## TABLE 2.3 cHECk-RAS Report

HEC-RAS Project: Plan File: Geometry File: Flow File: Report Date: dam9diversion\_final.prj dam9diversion\_final.p02 dam9diversion\_final.g01 dam9diversion\_final.f02 3/1/2012

RS = 328.0238

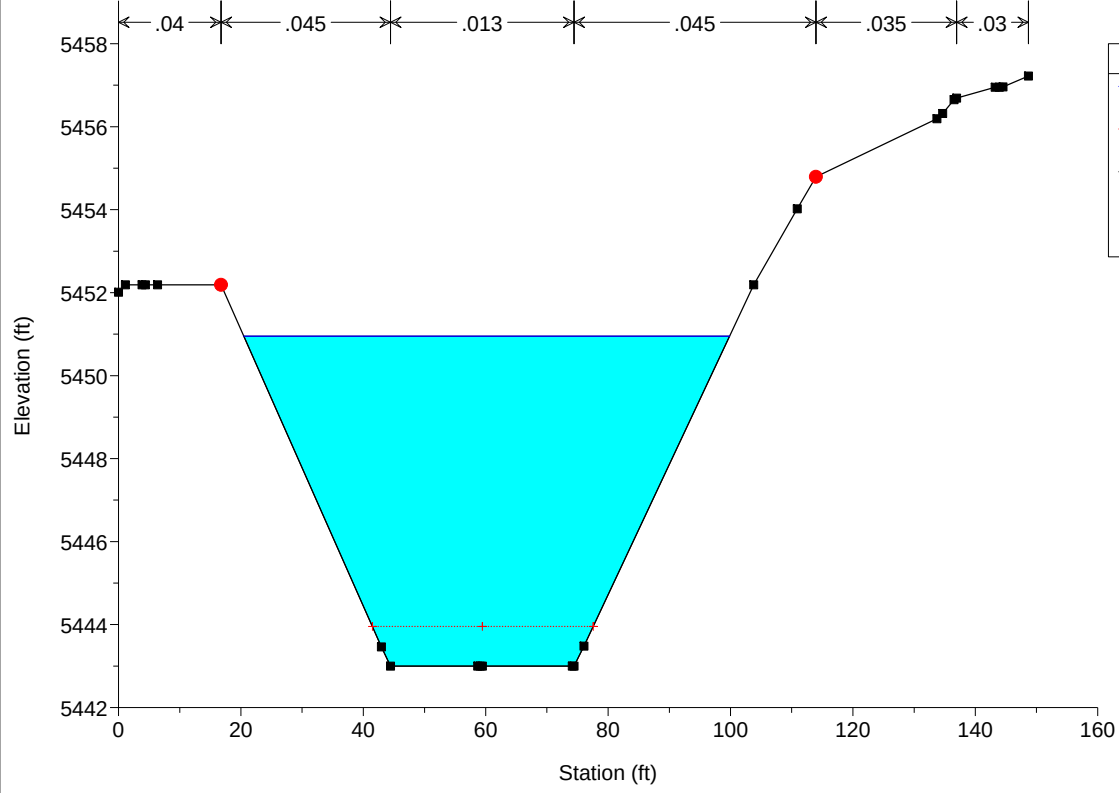
XS SW 01DK	The name of the stream is \$streamname\$. The flow regime is subcritical or mixed flow. Starting WSEL is computed from Known WSEL as the downstream boundary for \$Assigned_Name\$ flood. Provide backup information on Known WSEL or use energy slope as the downstream boundary.	328.0238	Known WSEL established per culvert headwater analysis described in Additional Explanation document for MT-2 Form 2.
